Rezoning Transportation Analysis
Petition Number: Insert Zoning Petition #2021-199
General Location Identifier: Tax ID 08307315

Revision Log:	Date	Description
	12-28-2021	First Review (AO)
	01-25-2022	Second Review (AO)
	04-26-2022	Third Review (AO)

Transportation Summary

SHEET NO:
RZ-1

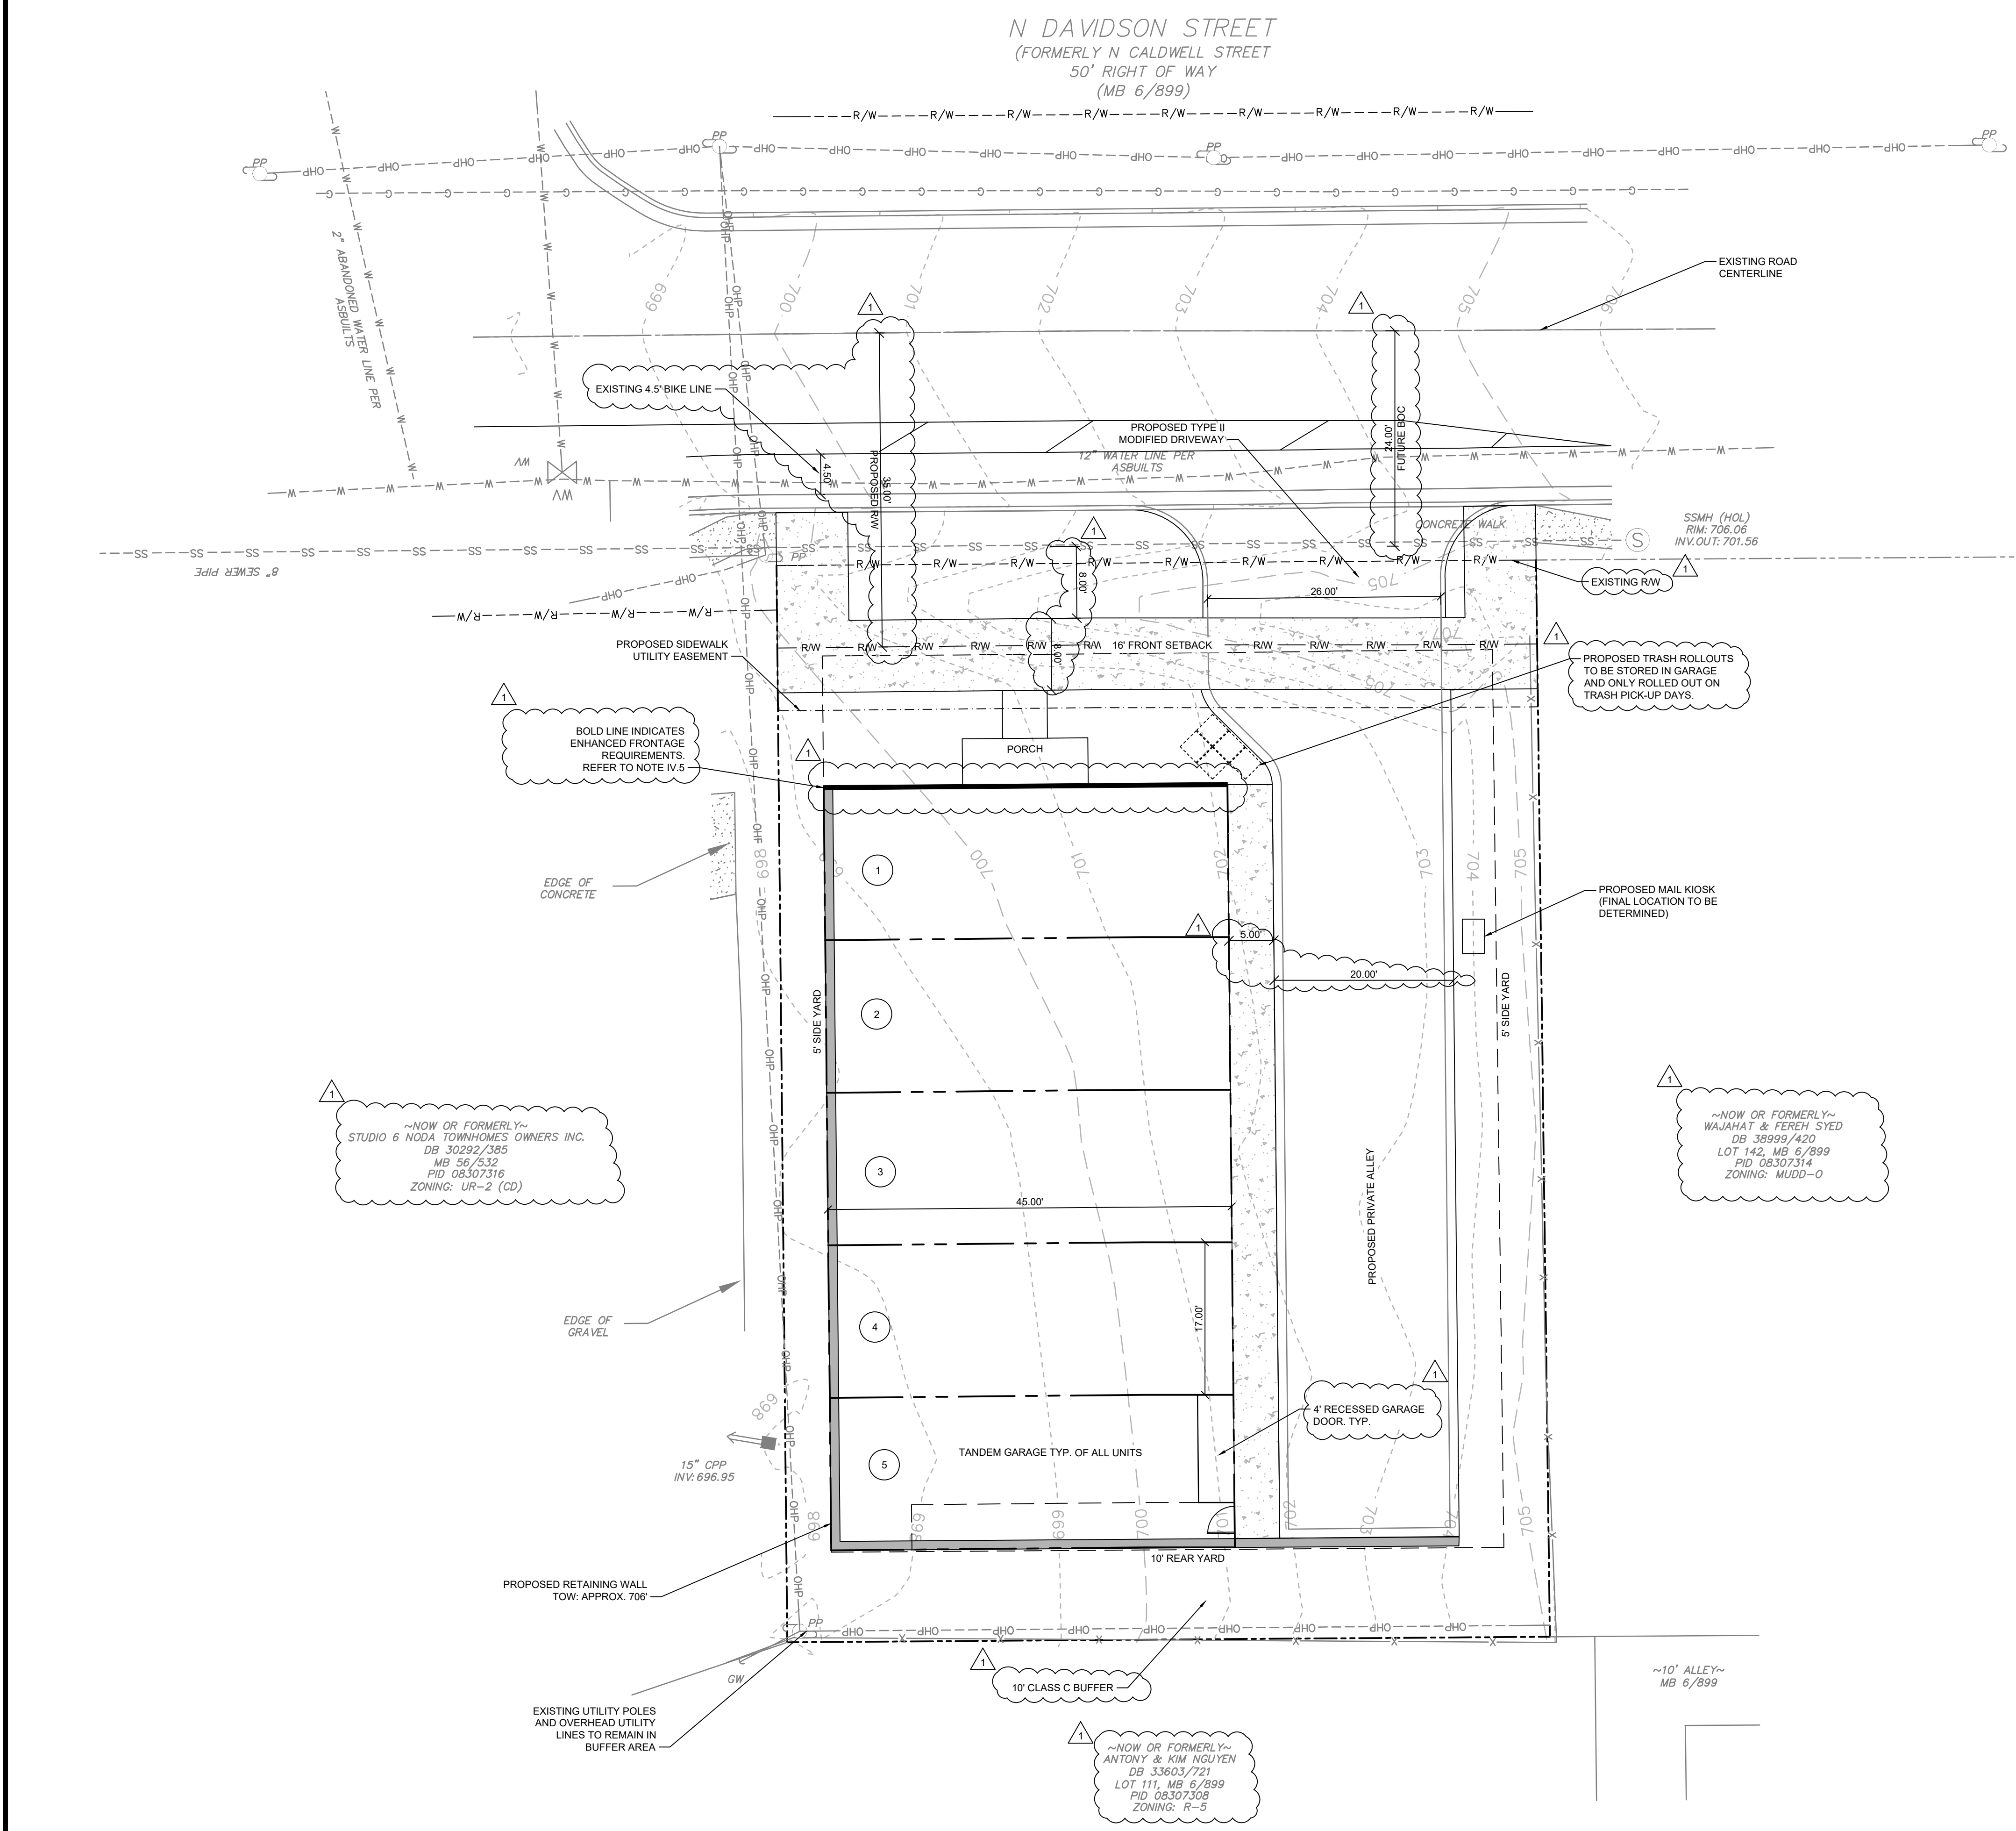
3. **Update to Comment from 12-28-21:** Revise site plan and conditional note(s) to commit to dedicate 30' of right-of-way from the road centerline. The site plan shall label and dimension the right-of-way from the road centerline.

- 8. **Outstanding Comment from 12-28-21:** A site plan note(s) specifying dedication and fee simple conveyance of all rights-of-way to the City before the site's first building certificate of occupancy is issued is needed. CDOT requests rights-of-way set at 2' behind back of sidewalk where feasible.

- 9. **Outstanding Comment from 12-28-21:** A site plan note specifying that all transportation improvements will be approved and constructed before the site's first building certificate of occupancy is issued is needed. The petitioner may phase transportation improvements if said improvements and phasing are explicitly described in site plan notes.

- 10. **New comment (New Site Plan, 4-4-22):** Revise site plan and conditional note(s) to commit to maintaining existing bicycle lane along N Davidson St to meet the City Charlotte BIKE Policy.

- 11. **New Comment (New Site Plan, 4-4-22):** Revise site plan and conditional note(s) to specify 2' sidewalk utility easement set at back of sidewalk.
